REF: N139961

DATE: 7 December 2018

RE: USYD ENGINEERING AND TECHNOLOGY – RESPONSE TO DPE COMMENTS

Reference is made to the DPE response received by Laing O'Rourke concerning the Traffic Management Package dated 11 September 2018 that formed part of the submission in response to stakeholders' comments.

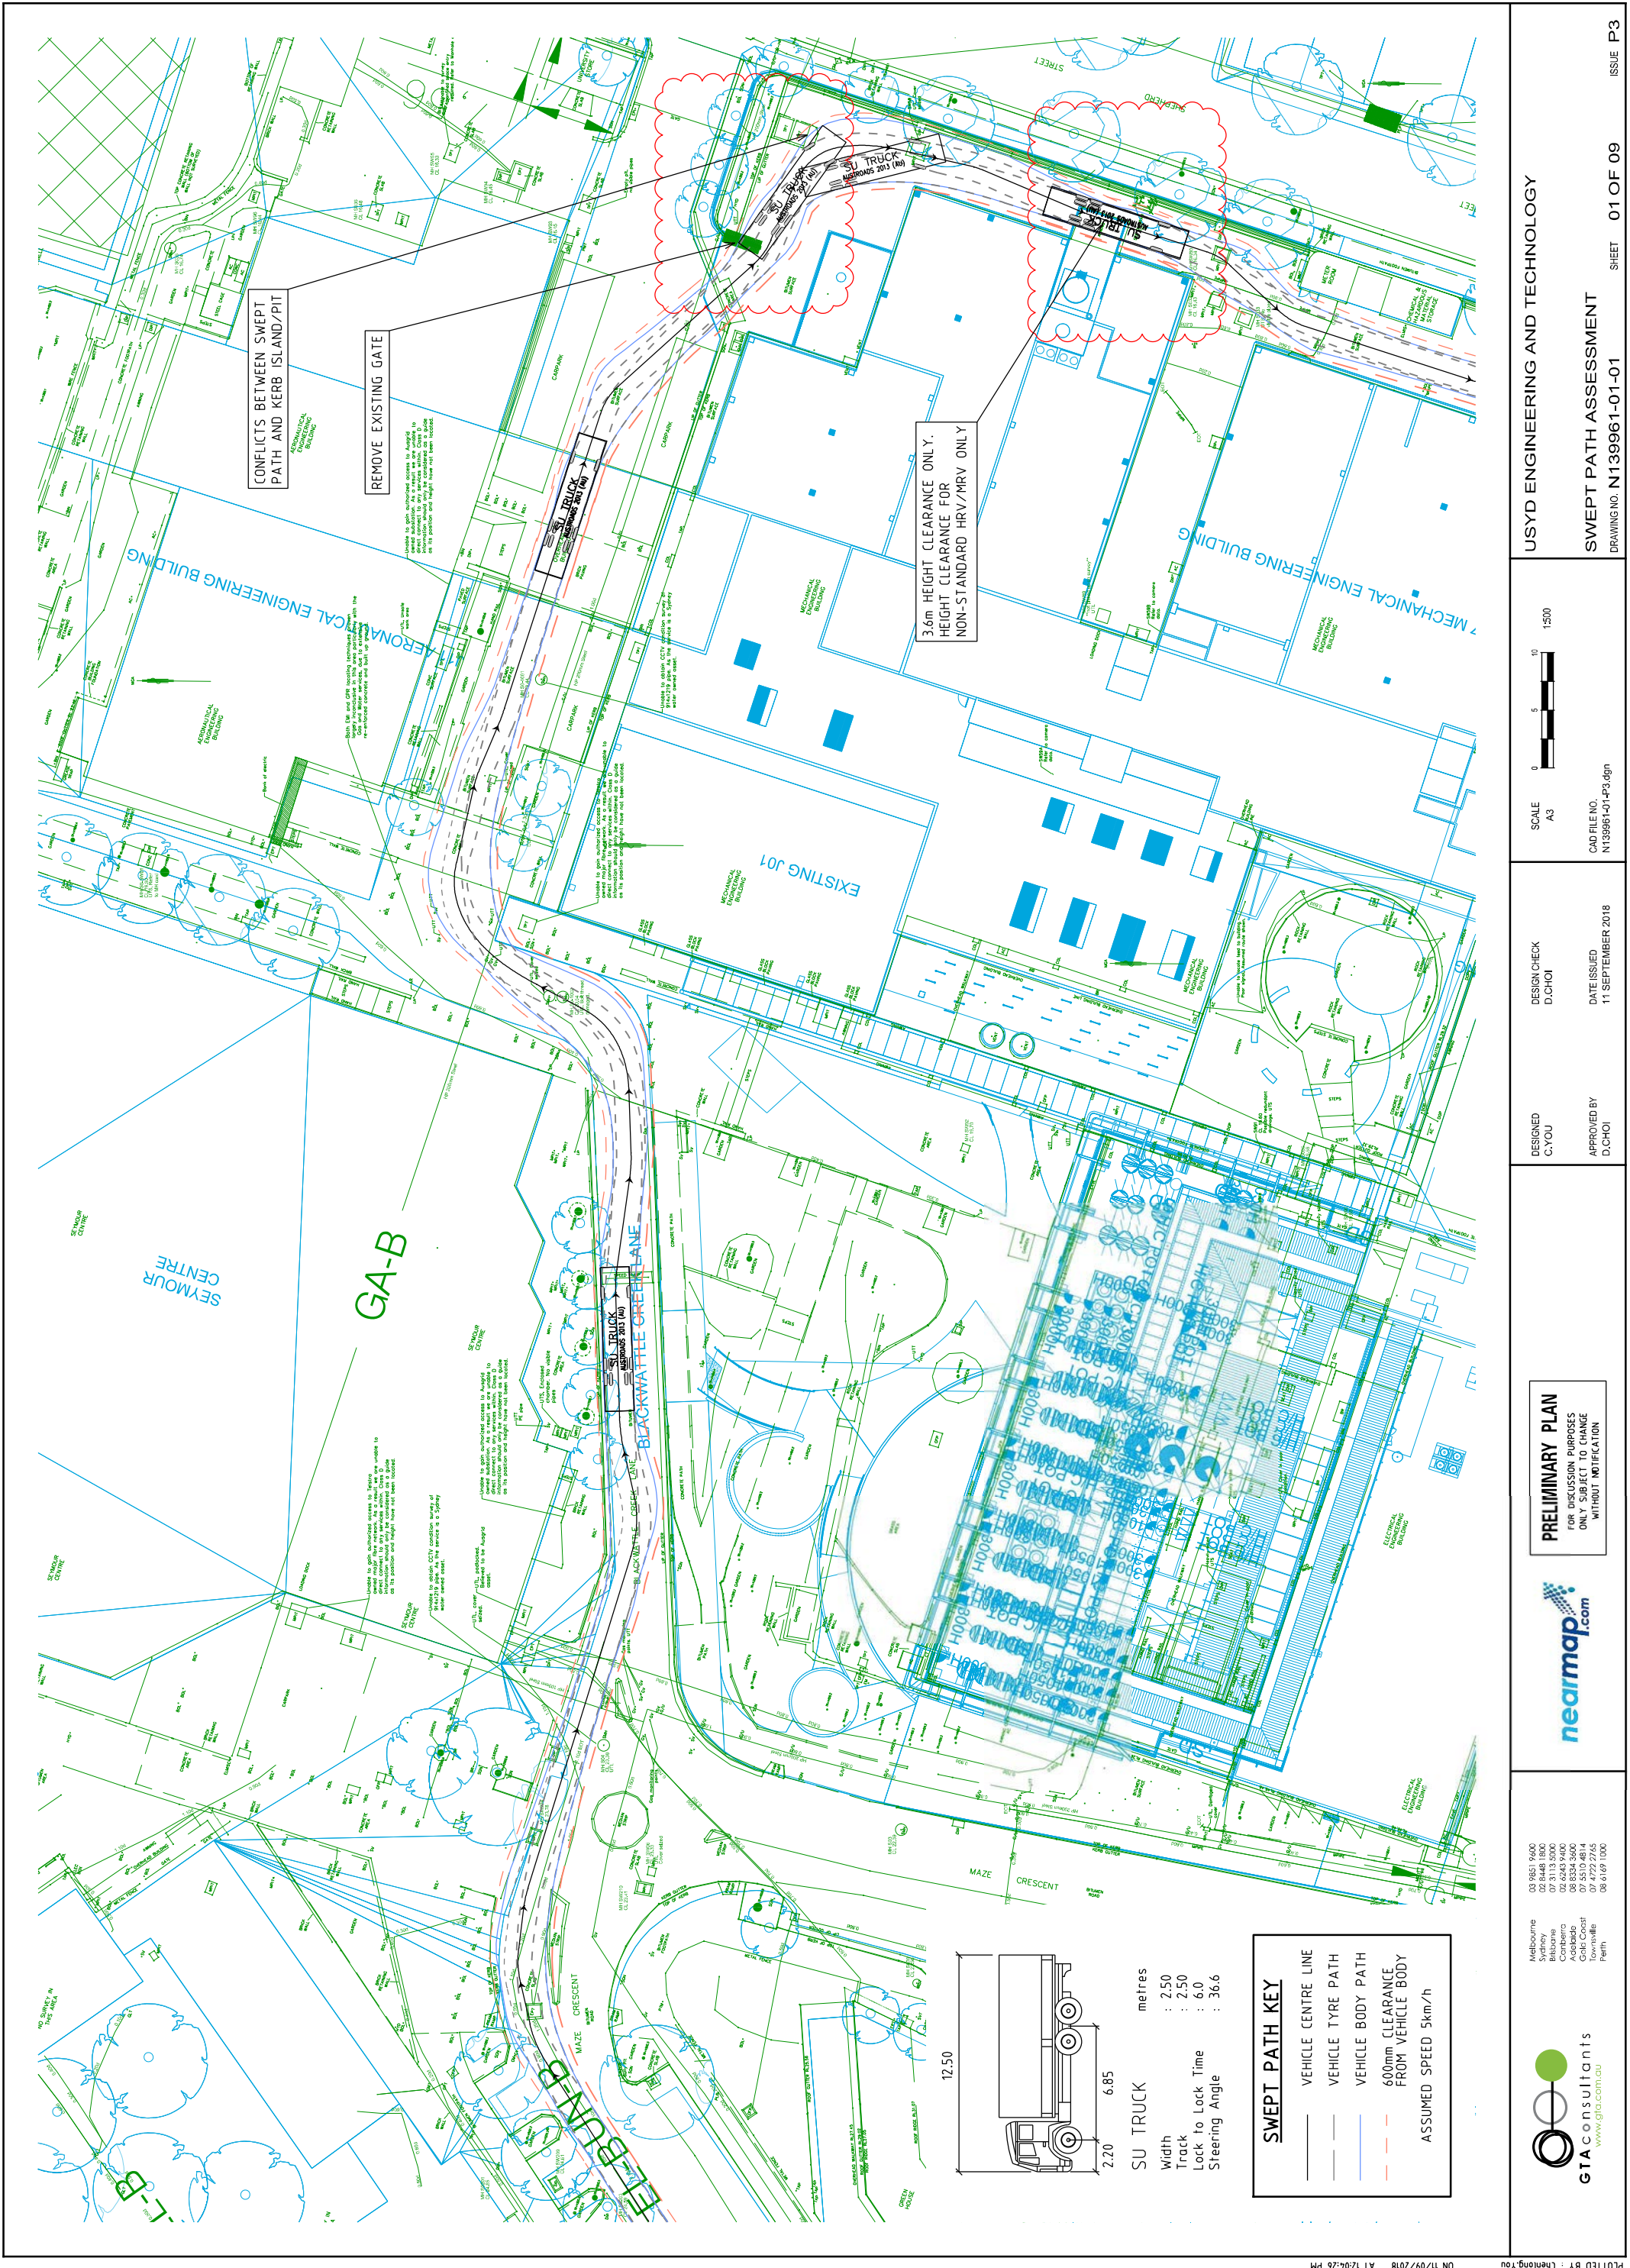
"Swept Paths for HRVs and MRVs show a number of conflicts with existing structures, including the hazardous materials storage building. The assessment does not advise how there will be resolved."

Chemical and Hazardous Material Storage (Location 02)

It is noted that the only vehicle that may conflict with the Chemical and Hazardous Material Storage is the 12.5m HRV. As HRV and MRV vehicles exiting the site will be managed via the implementation of a Traffic Guidance Scheme previously submitted, it is proposed that the University's nominated staff that will be implementing the Traffic Guidance Scheme provide direction to HRV vehicles to perform a corrective manoeuvre to achieve a straight approach to the Chemical and Hazardous Material Storage.

This information should form part of the University's procurement process to ensure suppliers are aware of the requirement.

Refer to the attached swept path for details.
